# Project Special Provisions (Version 06.6) Signals and Intelligent Transportation Systems

Prepared By: \_\_\_\_\_  
30-Sep-09

## 1. 2006 STANDARD SPECIFICATIONS FOR ROADS & STRUCTURES

*The 2006 Standard Specifications are revised as follows:*

ENGLISH DETAIL DRAWING FOR  
**INDUCTIVE DETECTION LOOPS**  
LOOP WIRE DETAILS

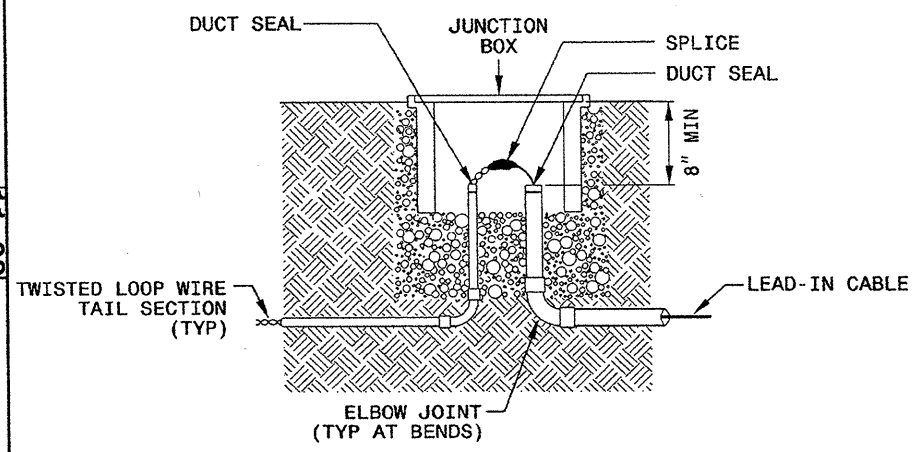
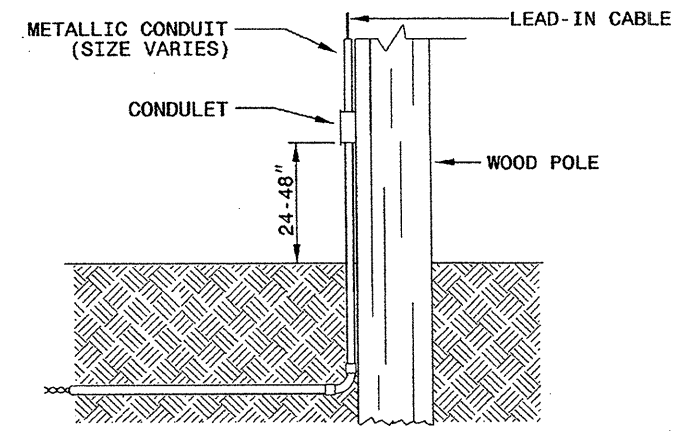
Page 17-20, Subarticle 1725-3, In the first paragraph, revise the first sentence to:

“Between where loop conductor pairs leave saw cut in pavement and junction boxes, twist loop conductor pairs a minimum of 5 turns per foot.”
